Subject: **Project Update/Review of Plans**
Proposed Single-Family Residence
4045 West Mercer Way
Mercer Island, Washington

We have completed a general review of the geotechnical aspects of the plans for the single-family residence to be constructed at 4045 West Mercer Way on Mercer Island. We completed a geotechnical engineering study for this project dated June 18, 2021. The City of Mercer Island has recently prepared comments regarding the geotechnical engineering aspects of this project, and has also asked for us to review the plans. Our response to the comments, as well as our review of the plans, is included in this letter.

GRADING PLAN

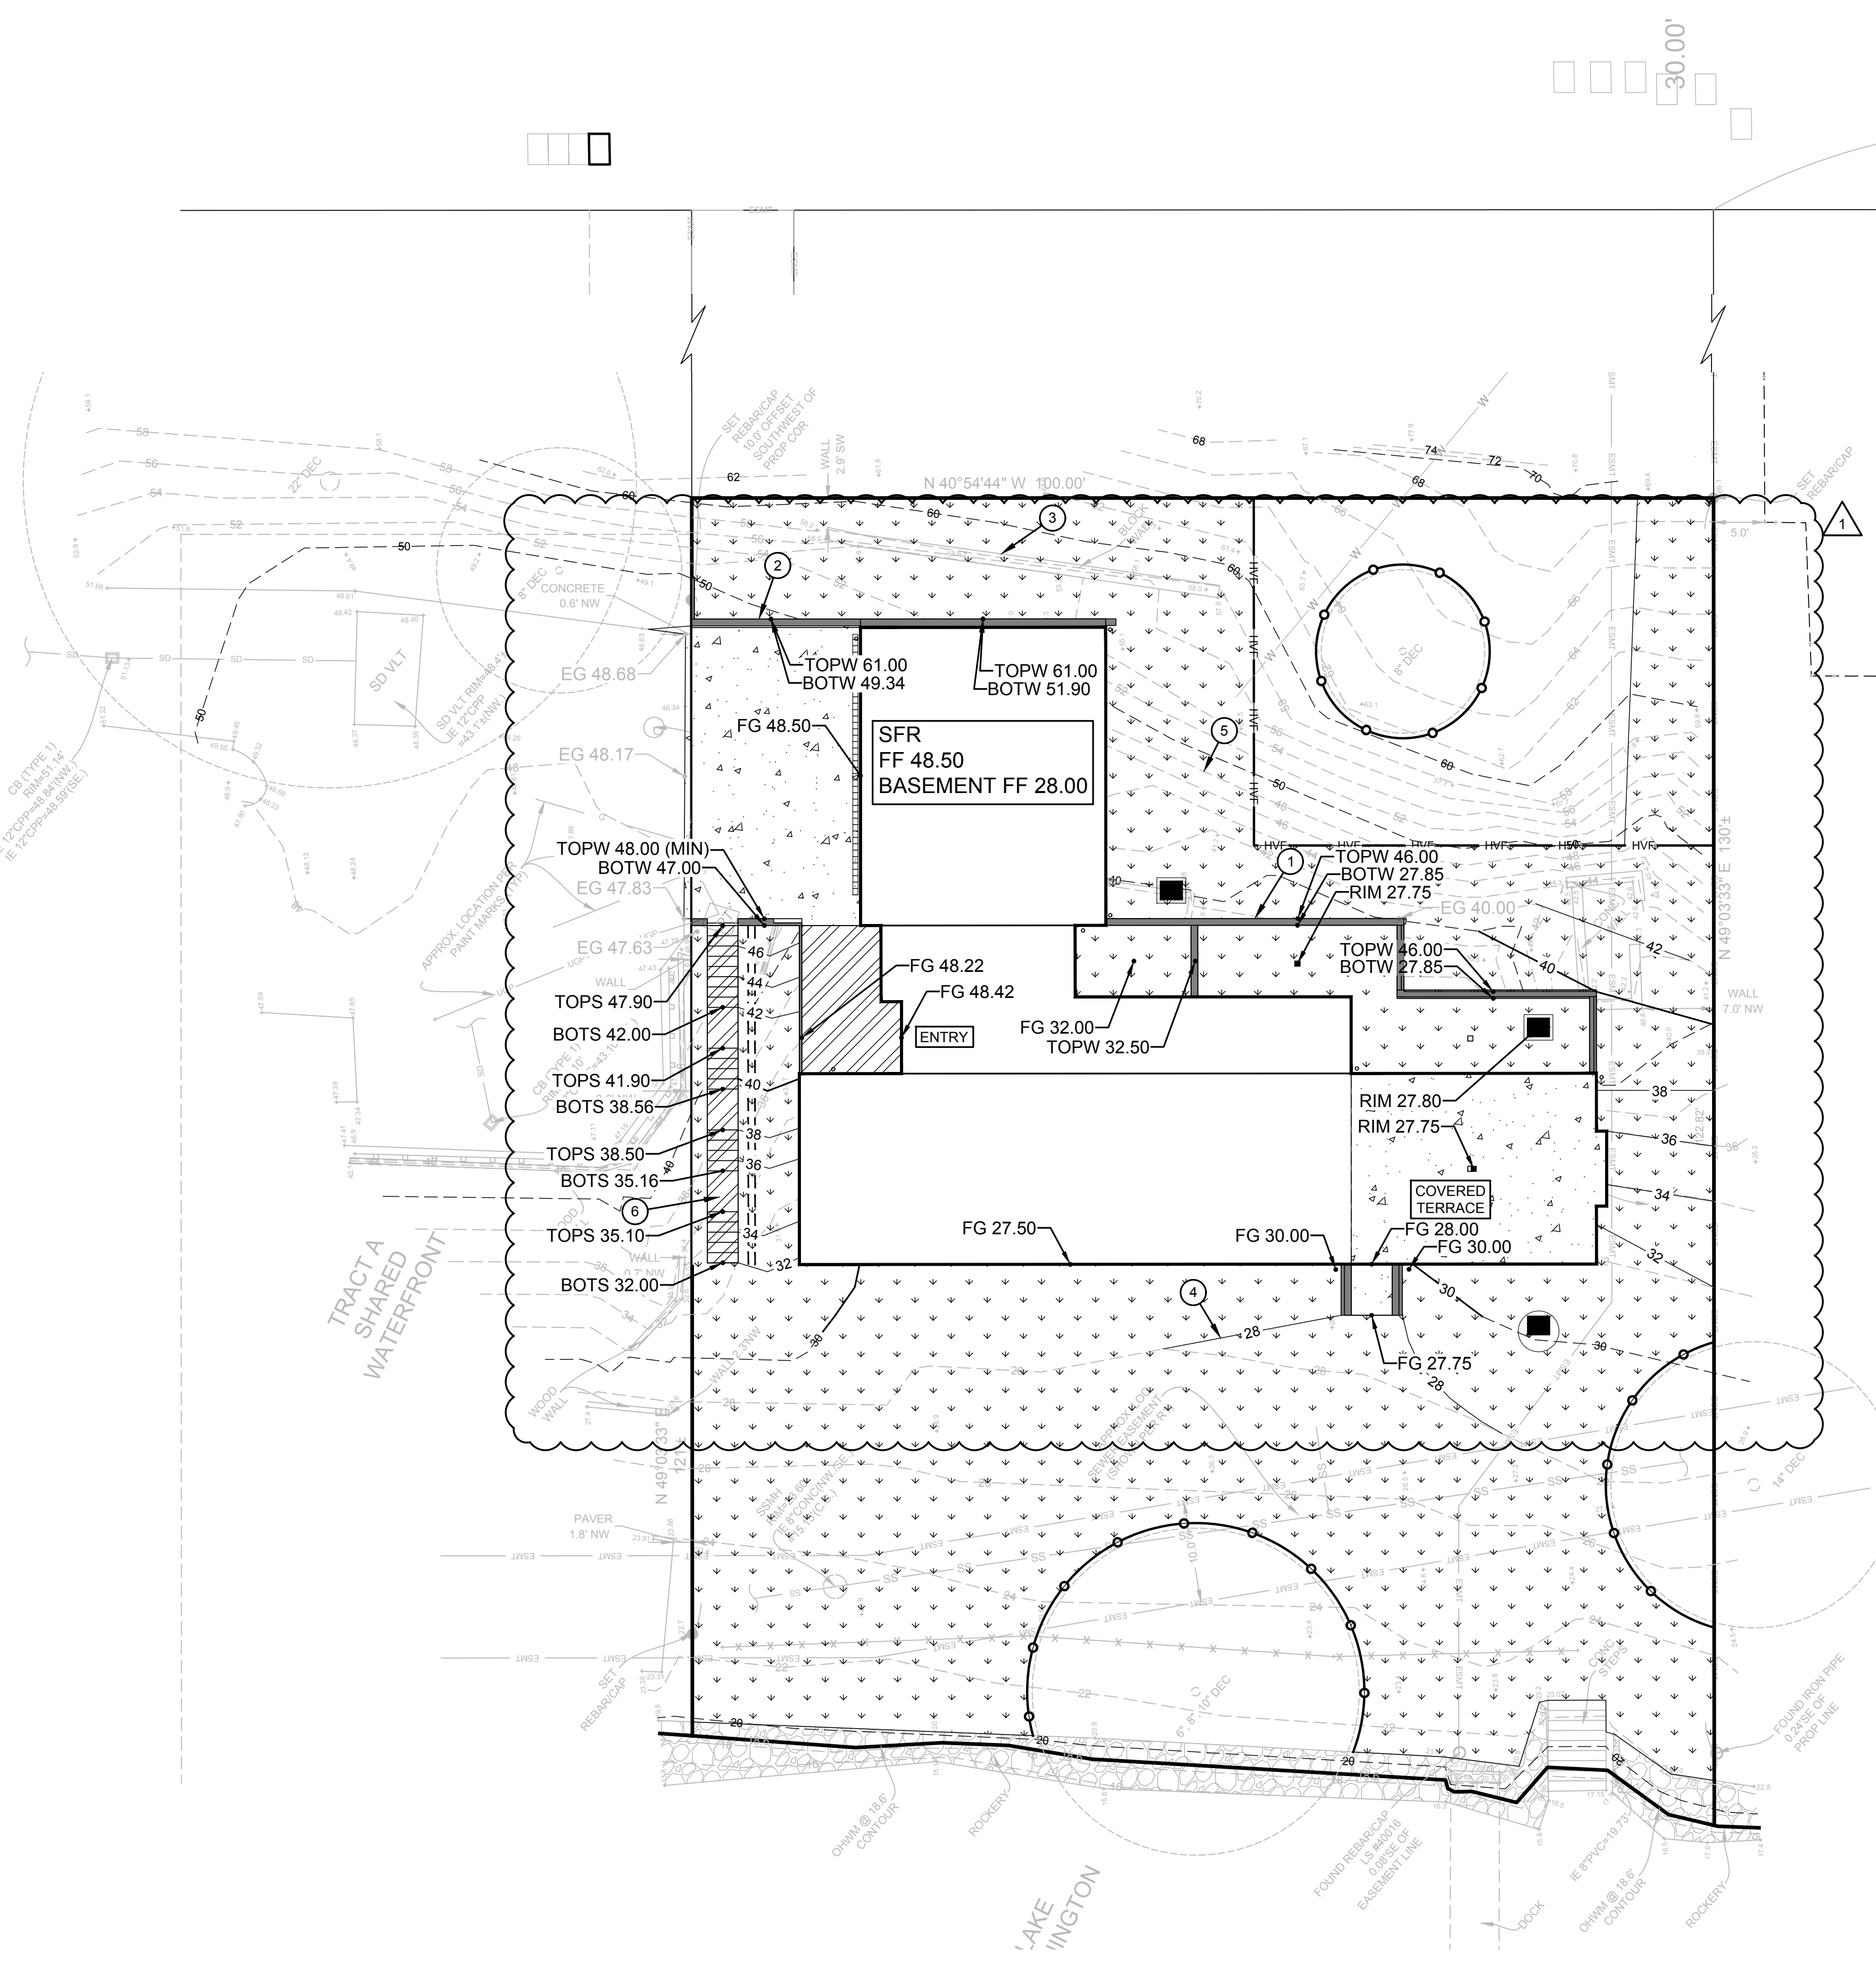
Based on Mercer Island review, additional info is needed regarding “catchment walls” that we recommended for the northern, upslope side of the proposed residence. In our study, we recommended the use of catchment walls on the upslope side of the residence if a potential landslide were to occur. We recommended that a catchment height of 7 feet for the garage portion of residence (northwest portion) and 6 feet on the northeast portion. We have recently reevaluated the catchment situation using data from landslides that have occurred frequently in the Alki Beach area of Seattle – this is the only data we know of in the Puget Sound area. and catchment walls are readily needed there. In 1974, landslide debris that included soil, boulders, and vegetation (trees, etc.) amounted to approximately 6.7 cubic yards (about 180 cubic feet) of material/foot of land. However, the slope this occurred on at Alki Beach is 110 feet tall. We analyzed the slope on the subject site, which is about one-half the size of the Alki Beach slope, thus we assumed the amount of landslide debris to be half of the 6.7 cubic yards. Using this amount, and assuming that the final landslide configuration would be approximately 3:1 (H:V), we have determined that the 6 feet of catchment is still suitable, but that the catchment wall at the garage needs to be raised to 8.5 feet. This increase in catchment height is included in the updated plans. We recommended that an active pressure of 80 pcf be used for the catchment wall; we have used this pressure for several years for catchment walls and believe it is adequate for this project.

The project plans have been recently updated, including the increasing of the catchment wall height to 8.5 feet in the garage area as noted previously in this letter. The plans we reviewed prior to the preparation of this letter include: 1) Sheets S1.0 through S4.3, which were prepared by Gary Gill, SE dated July 9, and 2) Sheets A0.1 through A8.1, which were prepared by McClellan Architects dated August 12, 2022 and 3) Sheets C01 through C07, which were prepared by DCG dated August 1, 2022

In our professional opinion, the plans conform to the recommendations in our geotechnical engineering report and geotechnical engineering recommendations we have made. We believe that the shoring and retaining wall design parameters are suitable as given in our report.
